Longacres, Eastergate Lane, Walberton, Arundel, BN18 0BA

30 May 2025

Drainage Technical Note

1. This Technical Note has been prepared to address the LLFA's objection comments – as set out in the "Engineers' Comments Regarding Surface Water Drainage" document dated 02/05/25, refer to Appendix C.

PROPOSED DRAWING 2a
Site Plan
November 2024
1:200 at A3

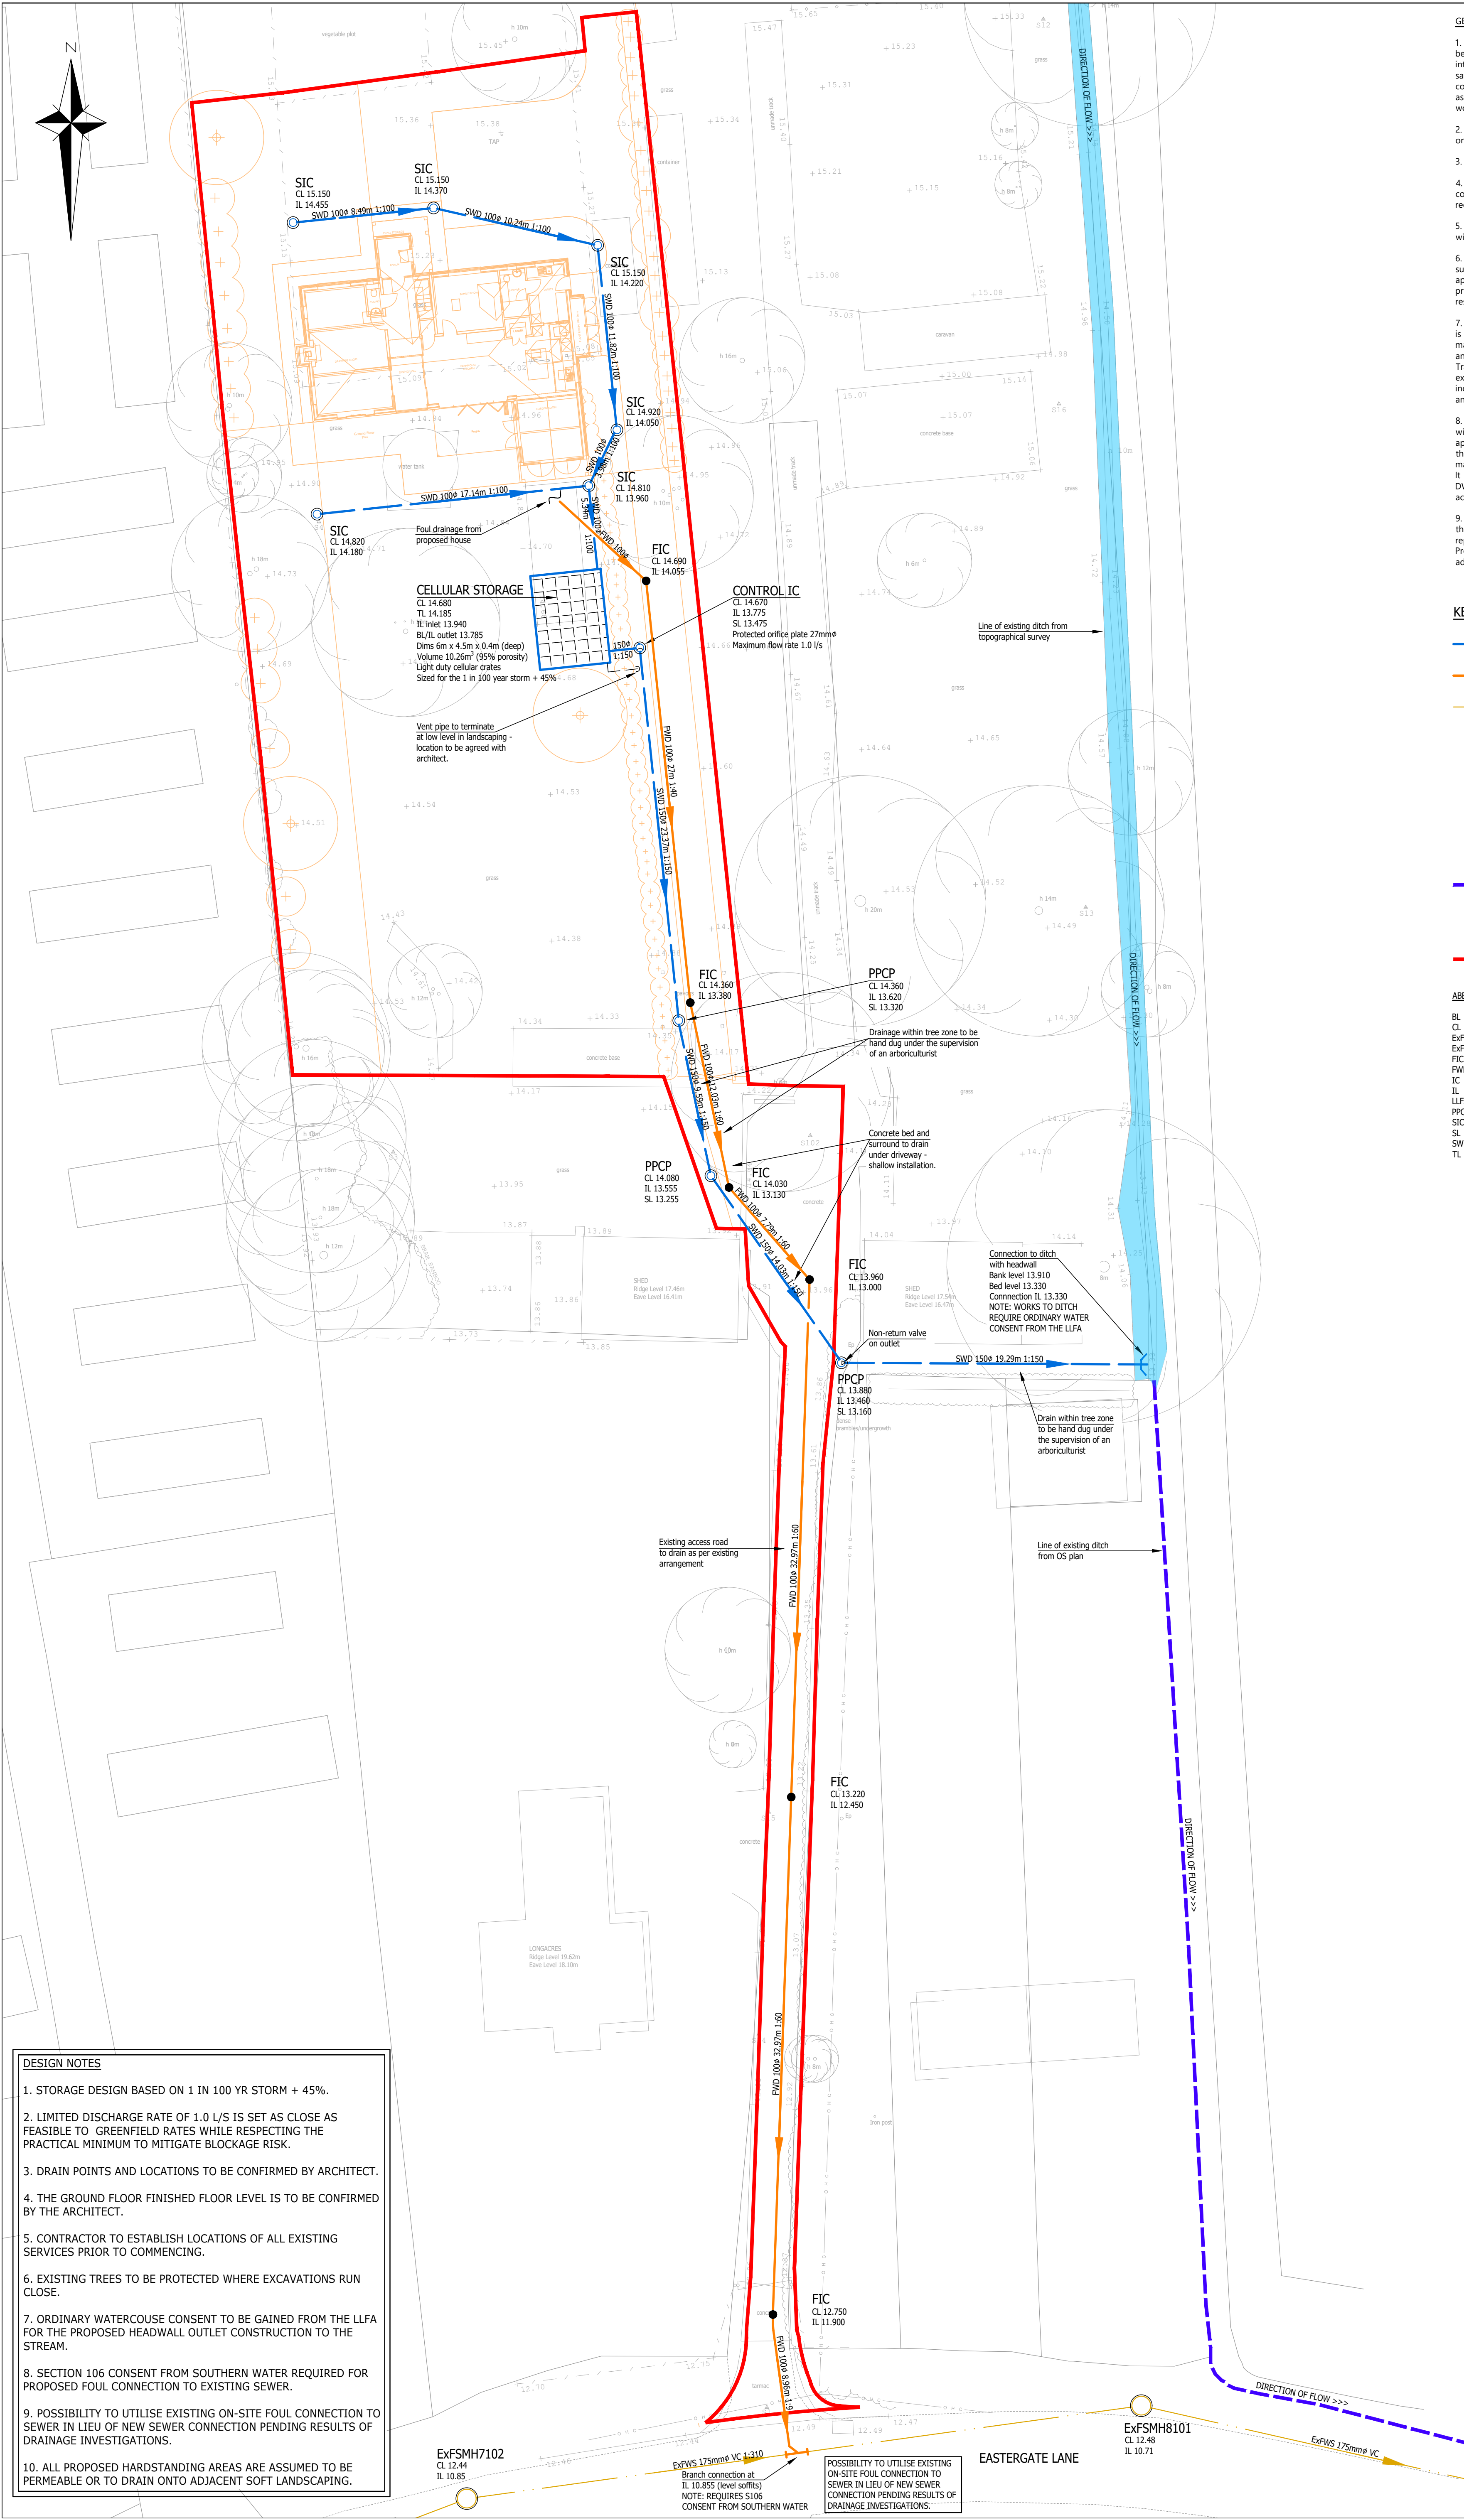
1. *The routing of pipework through the root protection zone of a mature tree. Given the species of tree, the roots could be detrimental to the operation of the pipeline in the future. Our tree officer will provide a consultation in this respect.*

2. *It is understood that the existing driveway will remain in its present form, however, it is noted the any new sections of driveway/hardstanding will be constructed with a permeable surface. The principle is acceptable, however, the new areas will need to be an engineered design. Thus, they will need to be incorporated within the overall drainage design.*

3. *The proposed discharge rate (QBAR) appears to have been calculated on the entire site area rather than just the impermeable area. This will need to be re-calculated accordingly (to also include the new driveway/hardstanding contributing areas) and a discharge rate agreed. Due to the low rate expected and potential orifice diameter, suitable measures will need to be put in place to reduce the risk of blockage.*

4. *The hydraulic calculations do not reflect the current design in terms of levels. However, the calculations need to be revisited as a result of the above, and must include the piped network and evidence of the impermeable areas used. Urban creep @ 10% also needs to be applied. Appropriate climate change allowance needs to be applied to all storm events. A surcharged outfall will need to be modelled. The surcharge level should be to the top of the bank if hydraulic modelling of the watercourse is not available.*

5. *An exceedance overland flow route plan needs to be provided.*
6. *No freeboard is being achieved between the proposed outfall pipe invert and the existing ditch bed. This is not acceptable as flood risk may be increased due to siltation and blockage of the outfall. Adequate freeboard needs to be achieved and agreed.*

7. *The proposed landscaping conflicts with the proposed drainage layout. For example, a tree is proposed in close proximity to the storage tank. The tree species and root protection zone at maturity will need to be shown to ensure no detriment to the structure. There is also new hedging proposed which could lead to root intrusion into the pipes beneath. This is important as tree roots could damage the liner and pipework, allowing groundwater to enter the system. This would consume storage that is set aside for surface water and thus increase flood risk.*

8. *Interception drainage has not been adequately considered by the submission. This is an important consideration as when the drainage system is designed in accordance with The SuDS Manual, runoff for the majority of small (frequent) events will be prevented from leaving the site. This is the first water quantity standard prescribed by the manual. Designing for interception is*

1. Following the tree officer's response to the application, the existing tree T1 (mature Eucalyptus tree) is to be removed as it is in poor condition and qualifies as 'unsuitable for retention' in the arboricultural report. On that basis, the proposed foul and surface water drain route can remain as shown without conflicts. The final leg of the surface water drain route to the existing ditch has been rerouted to resolve the conflict with the existing tree on the adjacent land. Appendix A includes the revised strategy layout.

2. The drainage strategy (in appendix A) has been revised to include the area of permeable paving. The drainage calculations are shown in Appendix B.
3. The offsite flow rate proposed in the submitted FRA report is based on the practical minimum limit of screened vortex devices. This rate is proposed because the Q_{bar} of 0.19l/s calculated for 1ha is considerably less. It is contended that a) there is no need for a greenfield calculation for the contributing area as this would show a lower rate, which would also be put to one side – and b) the risk of flooding would be increased if a screened vortex were designed for an offsite flow rate <1l/s. The orifice's diameter would be that small that buildup of twigs or other debris that manages to bypass the screen would increase the local flood risk – and this would be greater than any benefit of the reduction of flow rates <1l/s.

4. The drainage calculations have been updated to include 10% urban creep for the roofed area. The drainage calculations have been updated to reflect the complete proposed network as shown on the drainage layout in Appendix A. A 10% urban creep factor has been applied to all roof areas; an impermeable catchment plan is included in Appendix A. Climate change allowances have been applied to all events in accordance with the latest climate change guidance for the area. Additionally, a surcharged outfall scenario has been modelled for the 1 in 100-years +45% climate change event, to demonstrate that the network can cope when the ditch water levels are equal to top of bank levels – refer to the drainage calculation in Appendix B..

5. Exceedance flow arrows have been added to the drainage strategy layout – refer to Appendix A.
6. No freeboard is needed - because the SuDS drainage network has been designed to flow adequately in the surcharged condition – refer to the drainage calculation in Appendix B. The outfall has been designed to work in surcharged condition; and the drainage strategy now shows regrading of the ditch bed to achieve sufficient freeboard. This is shown on the layout plan and details will be covered by an OWC application in due course.

7. This item relates to the proposed landscaping. The proposed tank locations have been coordinated with the landscape proposals. Appropriate tree root barriers will be included as part of the works, in accordance with DCG recommendations for planting near drain pipes.

8. Water butts have been added to the drainage strategy. These are considered to be satisfactory interception features according to the CIRIA SuDS Manual (C753).
